**Addendum No. 1**

RE: Contract ID C202412

**Wake County (R-5169A)**

SR-1728 (Wade Avenue) From East of Faircloth Street To  
Glenwood Avenue and Capital Boulevard Ramps

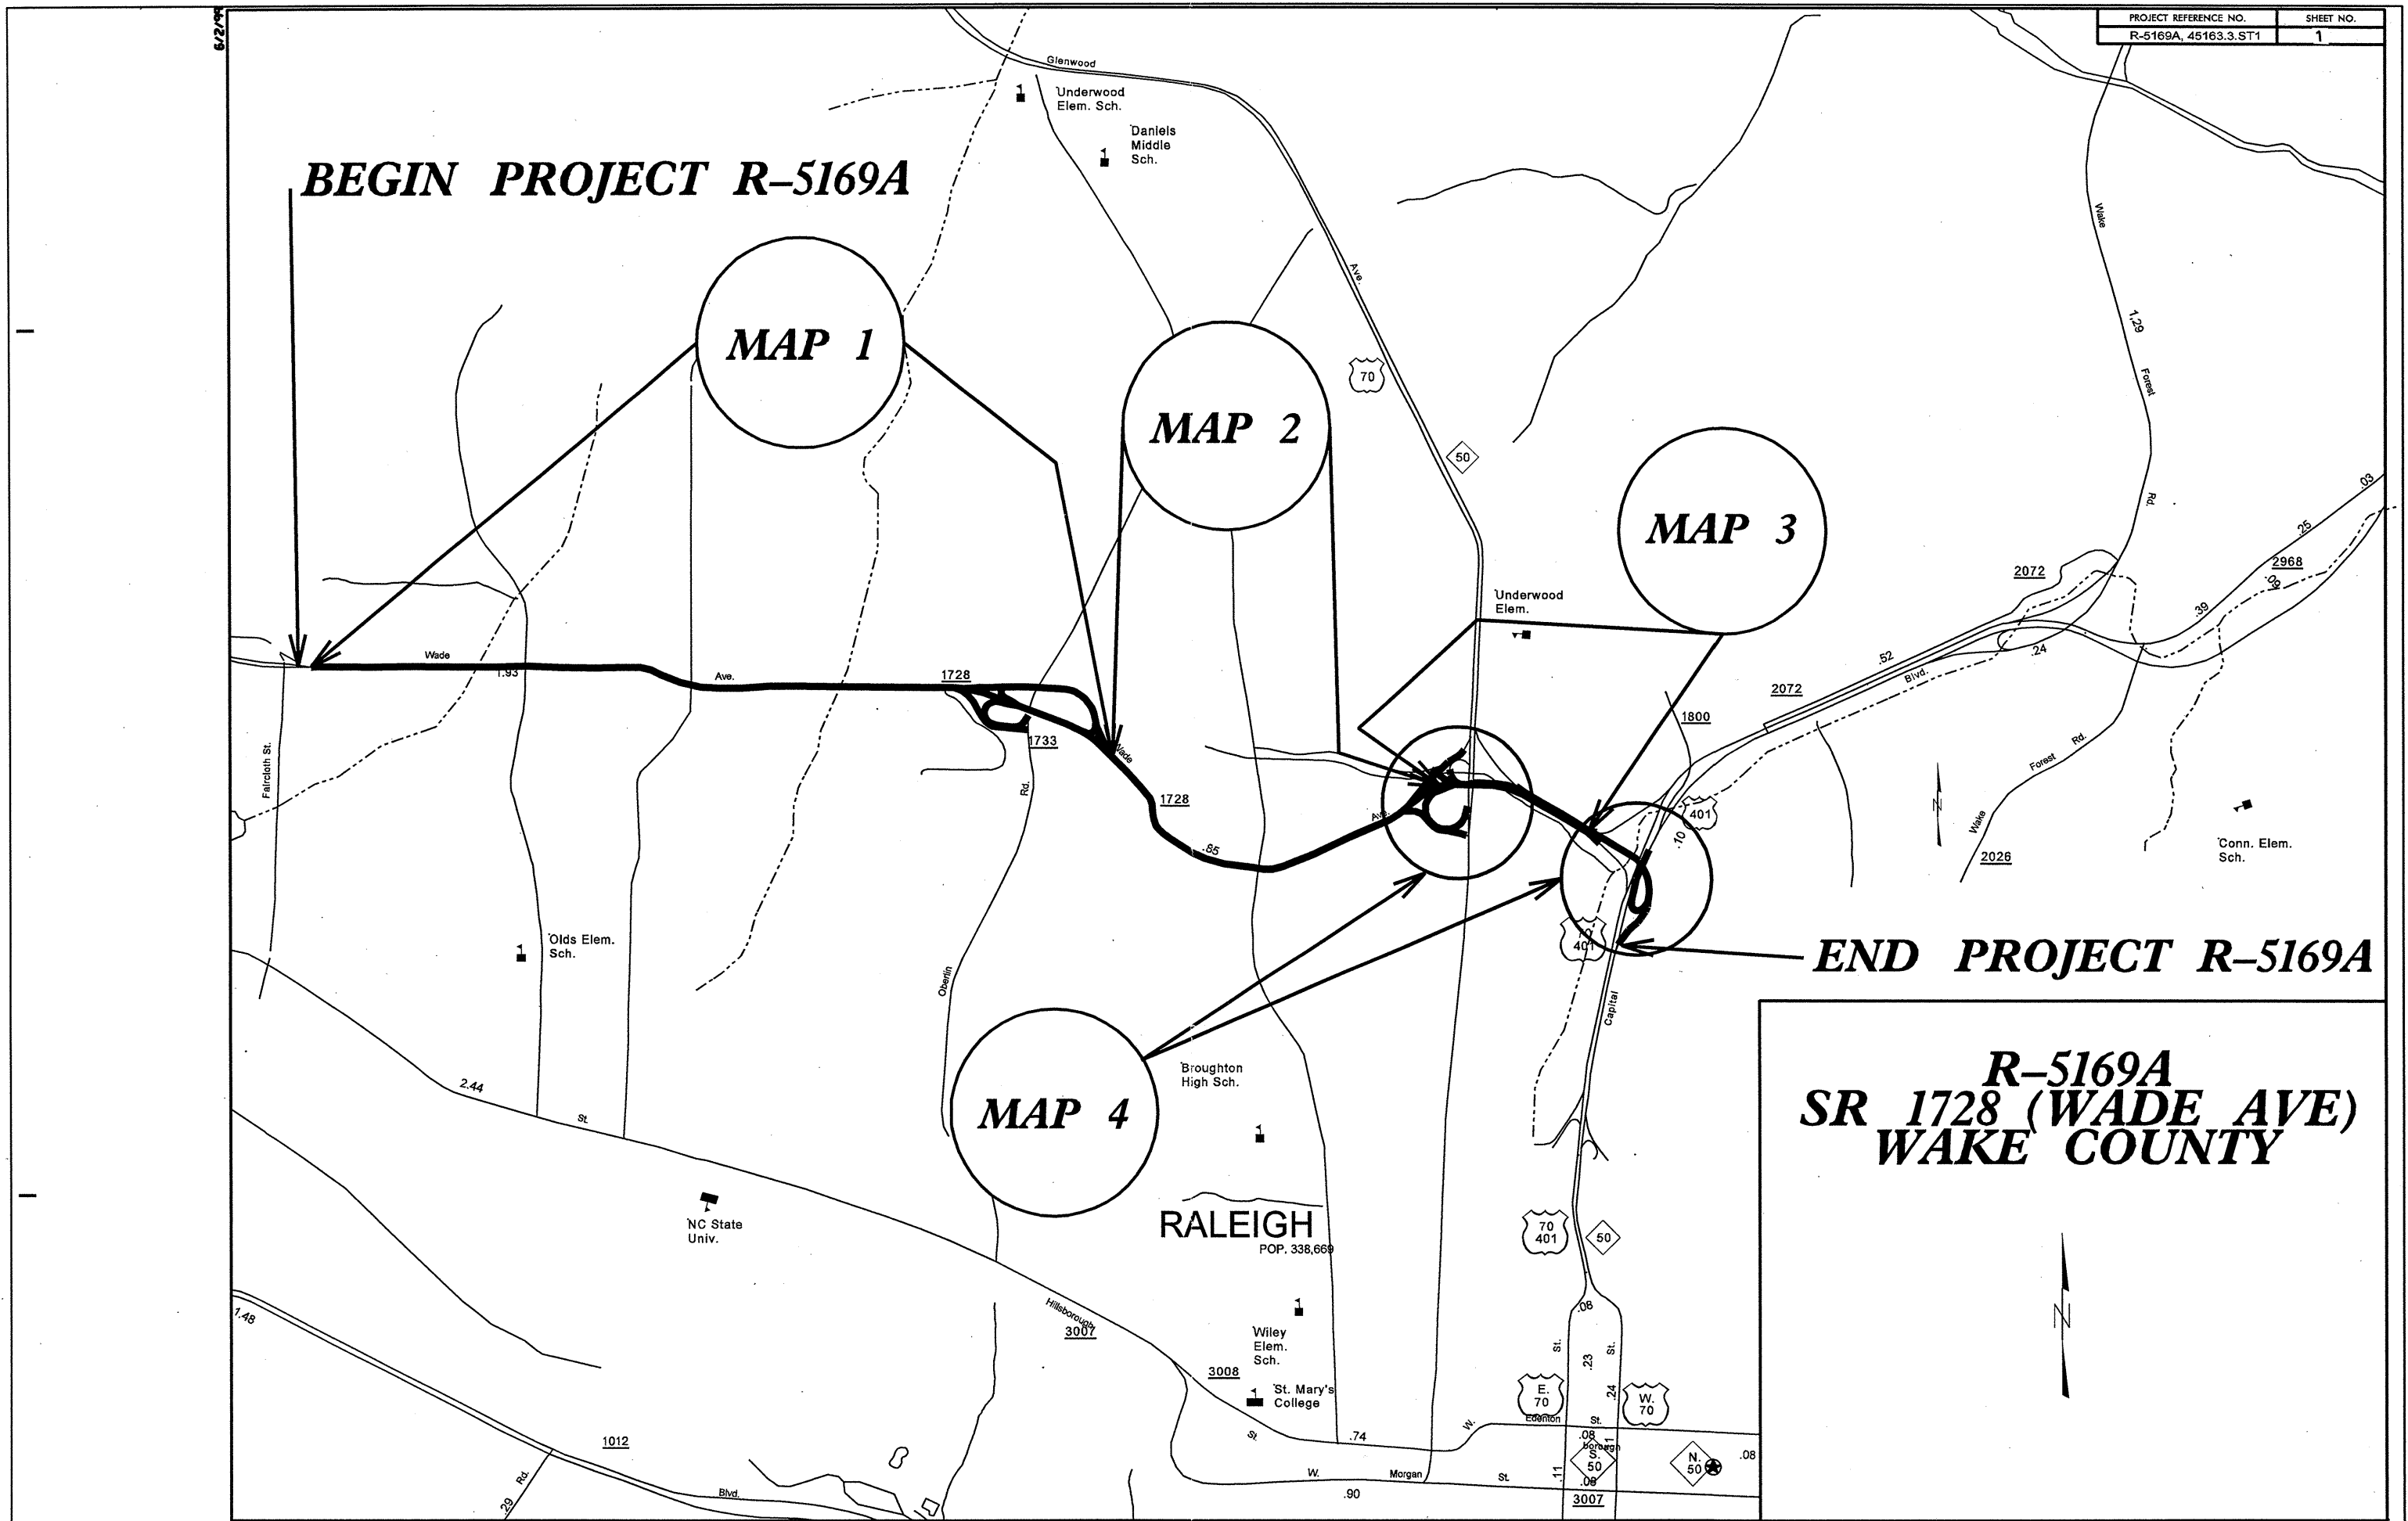
Sheet No. 1 has been revised to enlarge the project work area to better define the limits of the maps.

PROJECT NO.	SHEET NO.	TOTAL NO.
R-5169A 45163.3.ST1	3

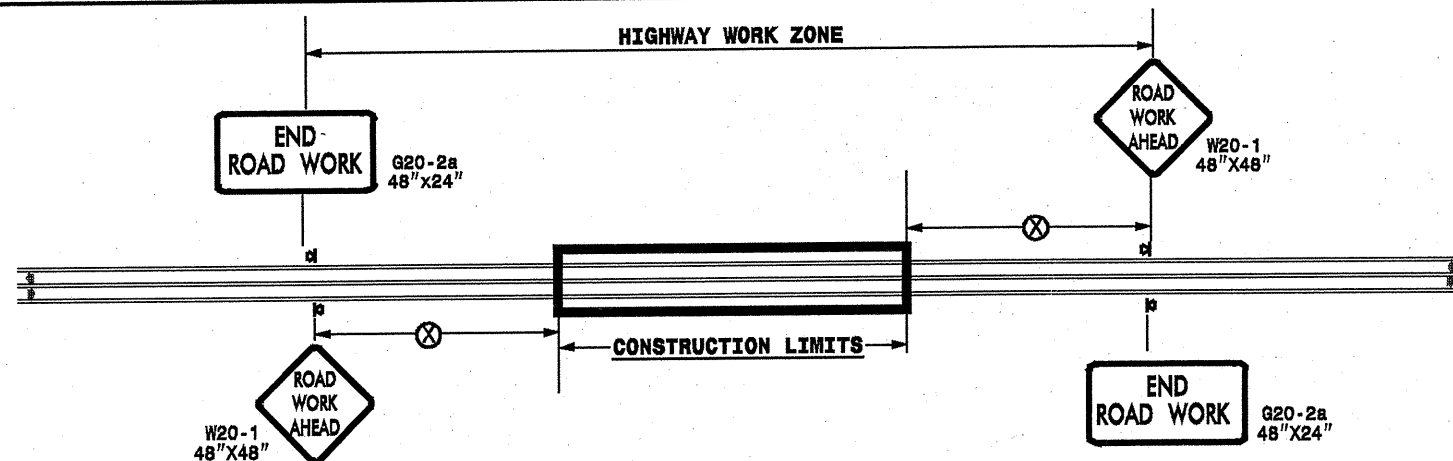
Sheet No. 3 has been revised to change the Summary of Quantities to reflect the above noted changes.
